Motion: to ~~grant~~ ^{find} ~~accept~~ amended plan of shed with building dimensions of 13'6" h x 9'6" w in compliance with building permit number 02-0173

Lynn Stanton of 7 Arlington Place, Tax Map #125, Block N, Lot #015 in the R-3 Zone is requesting a Interpretation Appeal from section 14-385 (restoration or reconstruction within an existing footprint of damages nonconforming building premises) of the Portland Zoning Ordinance. This would for the purpose of re-building a shed with dispute of original height. The Board granted the Interpretational Appeal 4-0 to allow the shed design as submitted to the Board.

TO: ZONING BOARD OF APPEALS
FROM: MARGE SCHMUCKAL, ZONING ADMINISTRATOR
DATE: APRIL 4, 2002
RE: 7 ARLINGTON PLACE – R-5 ZONE – 125-N-015

Front View

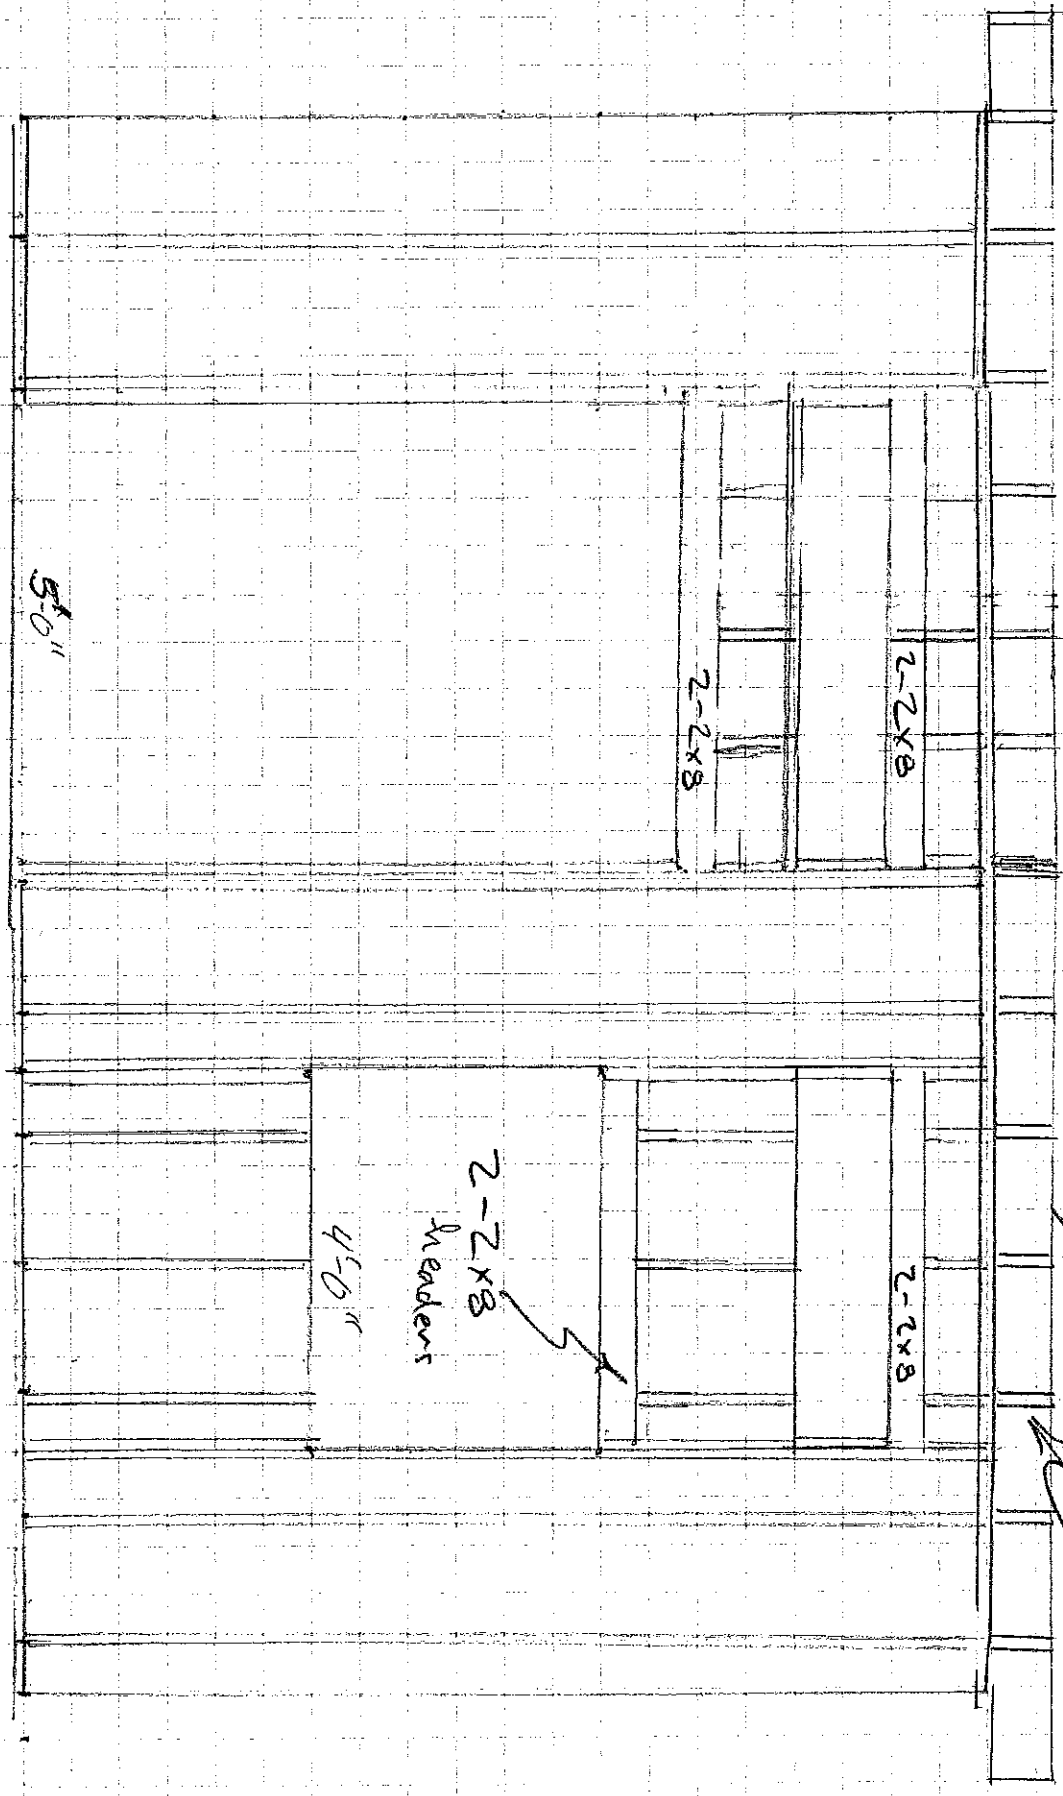
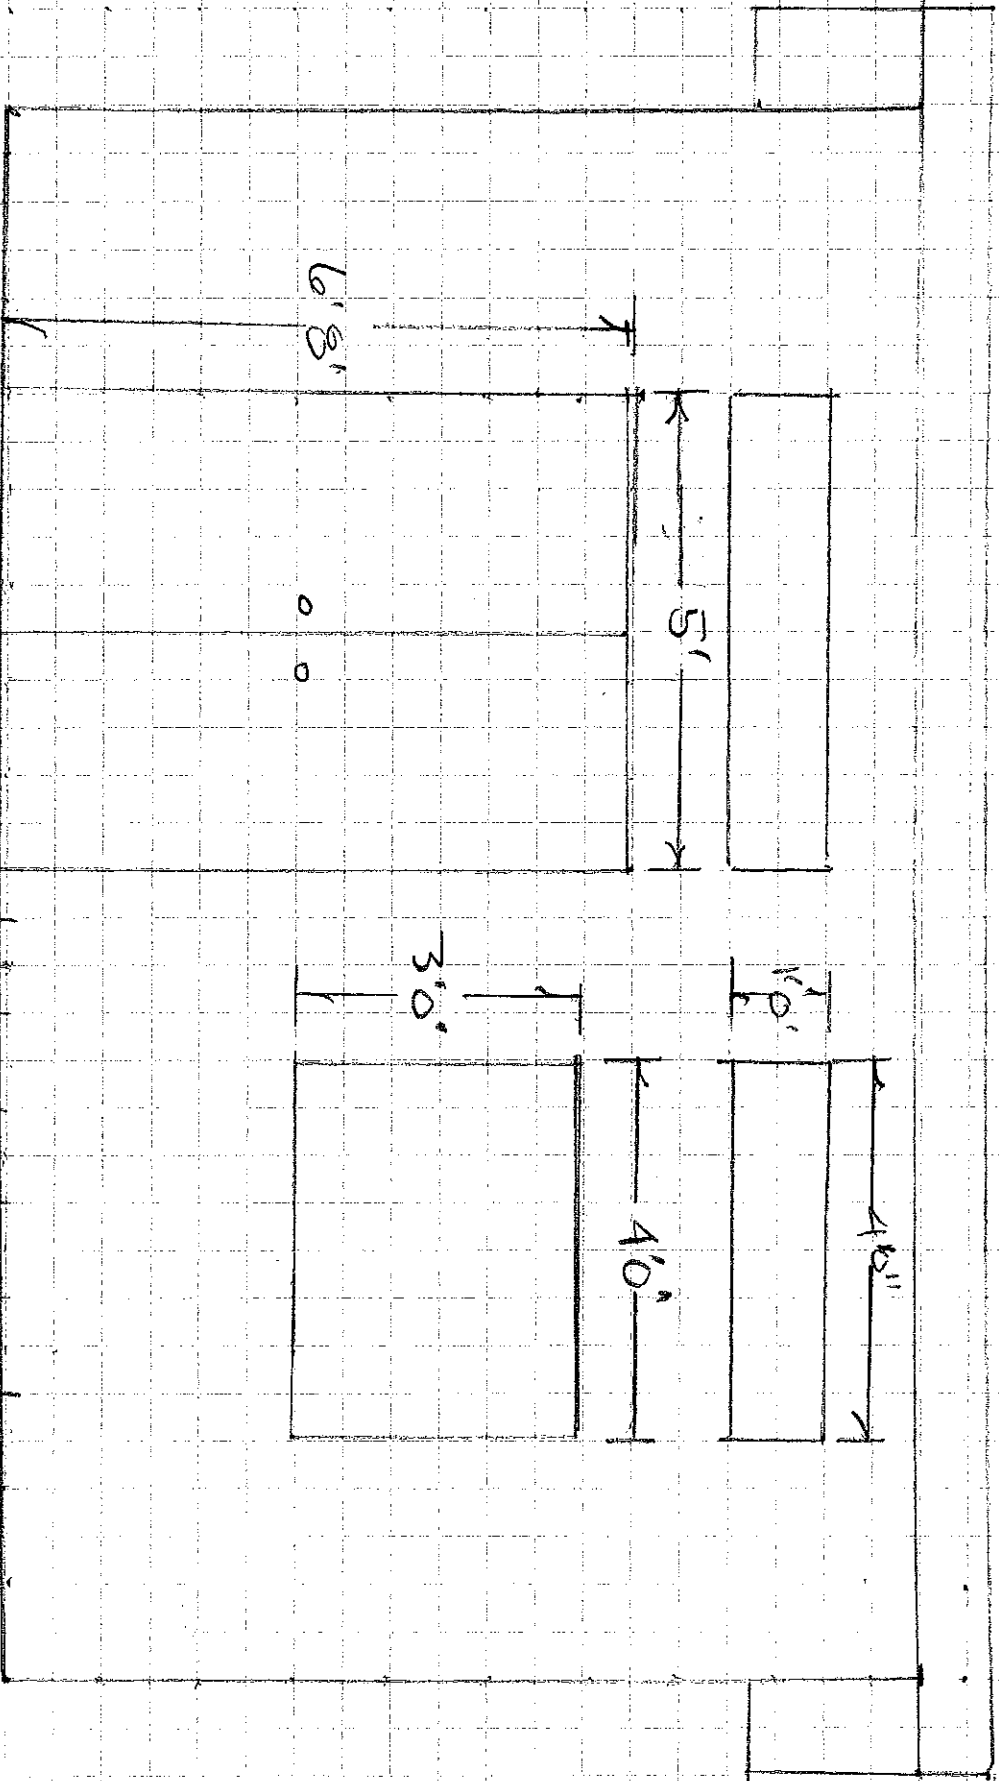
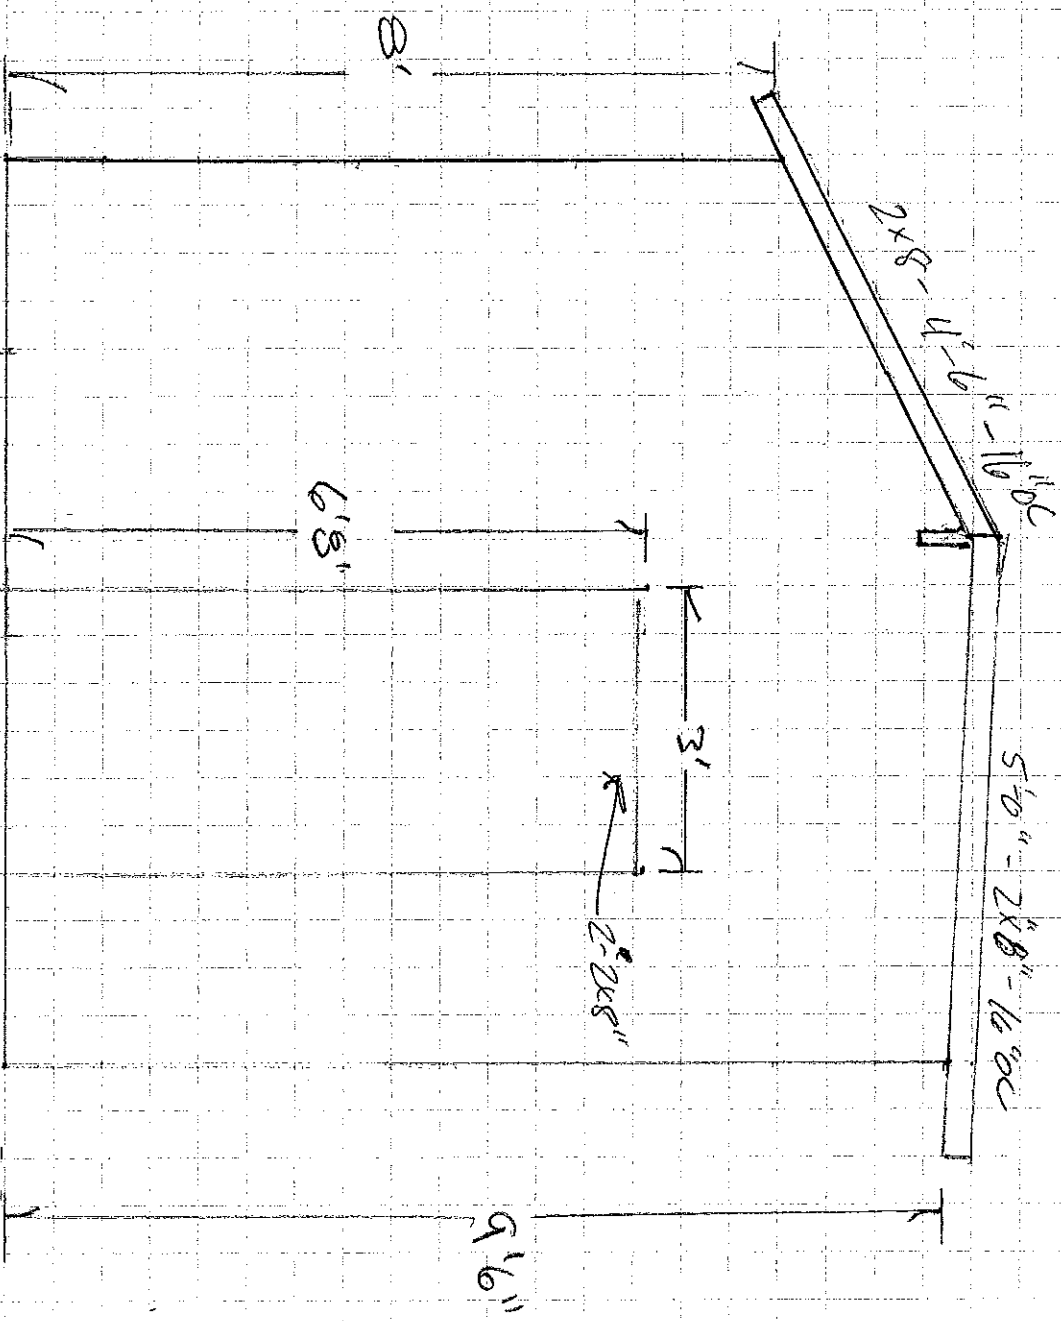
This interpretation appeal revolves around the height of the replacement structure. This shed structure was an existing nonconforming structure as to the side and rear setbacks. The Zoning Ordinance allows nonconforming structures to be rebuilt within one year on the same footprint, with the same setbacks, with the same dimensions (including height), and the same use. This was explained in depth, several times to the applicant and her builder.

We are basing our interpretation of the height of the original building by the photos that were submitted to this office, prior to the demolition of the shed. The photo (page 1) shows a normal door which we assume to be 6' 8" leaning up against the old shed. This door is not exactly at full height because of its leaning, but it is close to full height. The picture clearly shows the edge of the door to be hitting a foot or so above the edge of the lower roof line. The existing structure is not twice the size of this door or 13' 4". The applicant is proposing a new shed height to the ridge of 13' 6" (page 2). We believe that height is significantly higher than the original height.

Therefore, our office does not believe that the applicant's proposal is meeting the intent of the "rebuild" ordinance on either of the changes.

The Board determines that: the shed that was torn down may be replaced by a structure that is 13'6" h x 9'6" w in conformance with the building permit.
